CITY OF ALBUQUERQUE

March 24, 2022

**Re: Lighthouse Relocation
4208 Balloon Park Rd. NE
30-Day Temporary Certificate of Occupancy
Transportation Development Final Inspection**
Architect's Stamp dated 10-1-20 (E17-D019F)
Certification dated 3-16-22

NORTH
A1 SITE PLAN
1" = 10'-0"

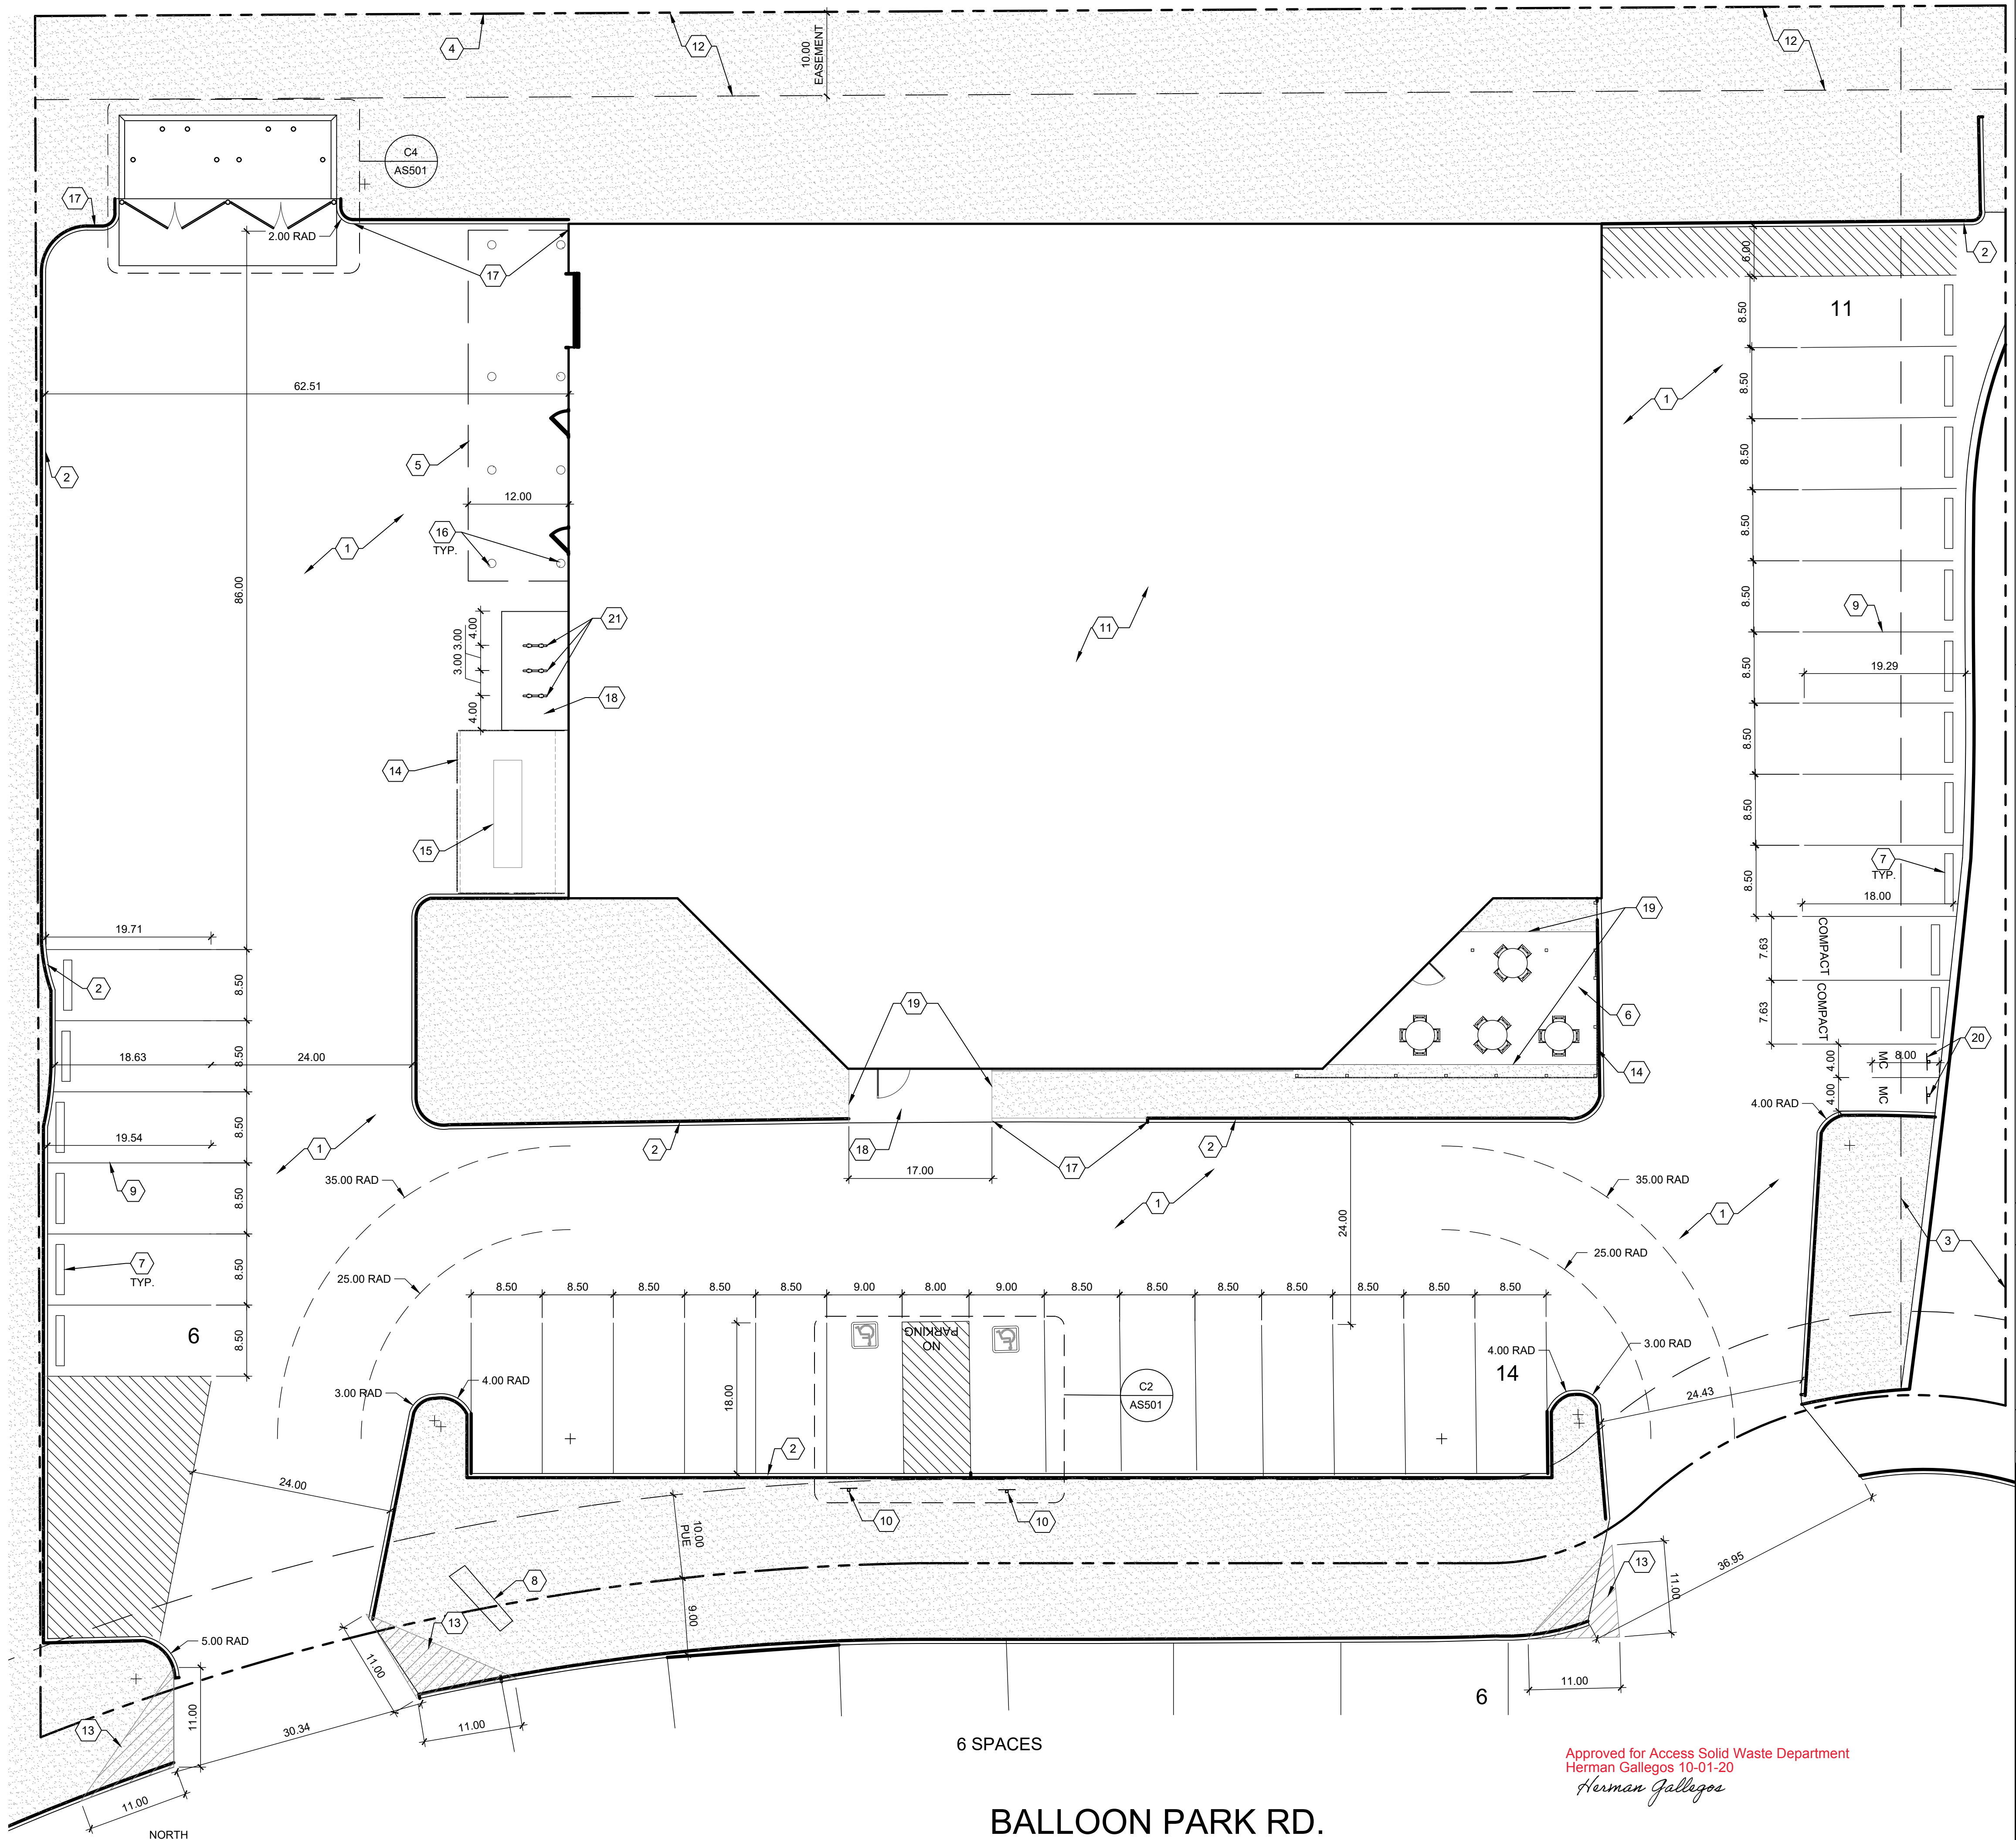
- Per DPM, a 6 ft. wide ADA accessible pedestrian pathway is required from the ADA parking stall access aisles to the building entrances. Please clearly show this pathway on the site.
- Provide Motorcycle Parking Sign, either free-standing or wall mounted per the zoning code.
- Parking Bumpers (per approved site plan) are missing on the site. Please red mark the approved site plan (TCL) and show that you have removed the Parking Bumpers.
